Reference: SSD8804
Contact: Susan Appleyard

State Significant Development 8804 – Expansion of Howlong Sand and Gravel – Request for additional information and clarification.

ADDITIONAL INFORMATION REQUESTED

**FIGURE 1-3 SITE LAYOUT**

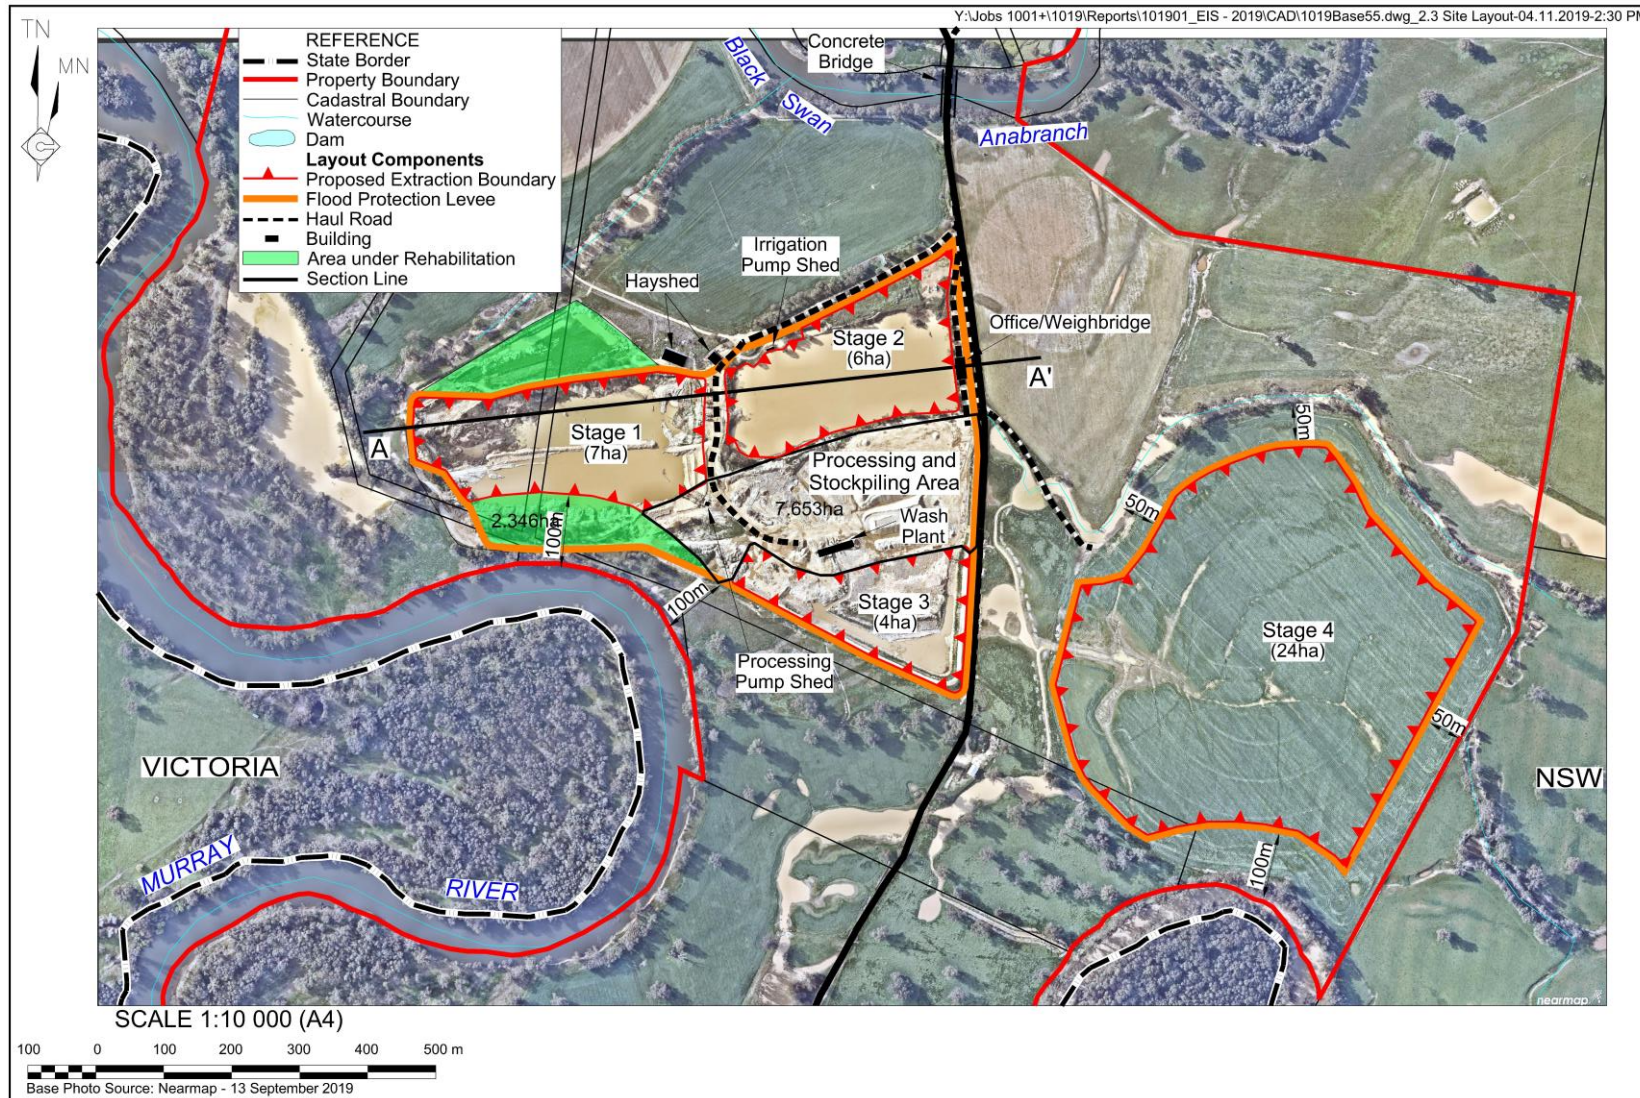
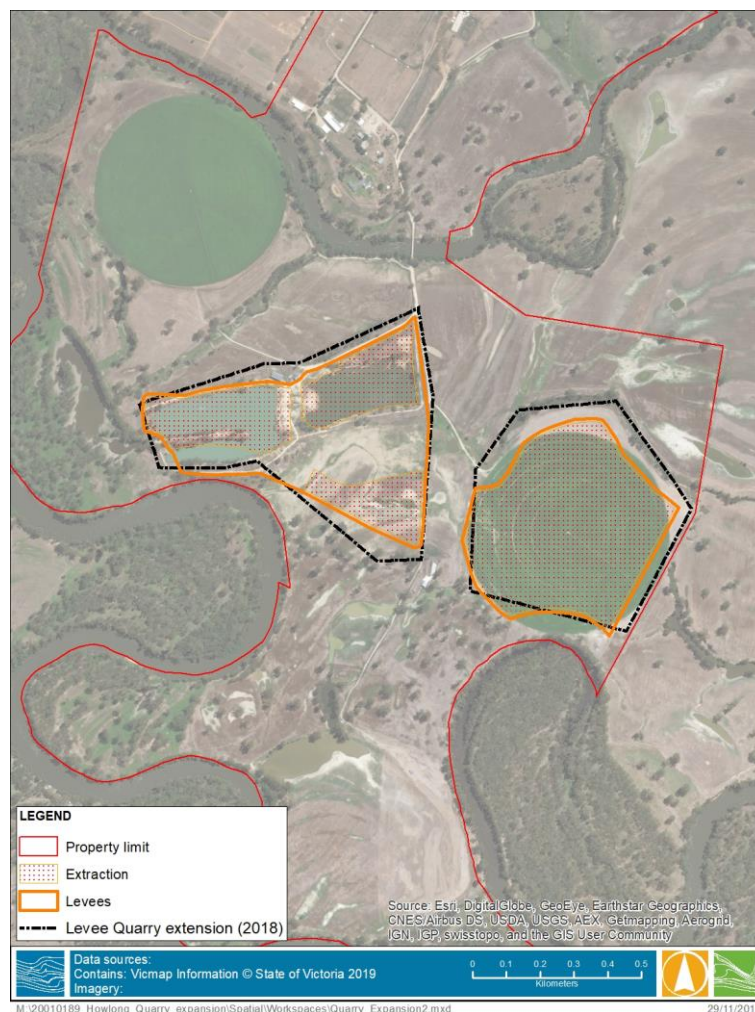
The proposal includes the construction of a levee to a maximum height of 2.7 or 147m AHD around stage 4 of the proposal. The study undertaken on the impact of the levee on flood flows only addresses the impact and protection of the operational area of the site.

The documentation states that the impact on floodwaters to the east will be for 4km at a height ranging from 300mm to 5mm, however it does not address if this effects on the Riverina Highway, the access to the site, neighbouring properties or other infrastructure on neighbouring properties. Council requests that additional information regarding the impact on flood waters be provided for both upstream and downstream of the site, and that such information includes the overland flow changes that will be caused by the construction of the levee.
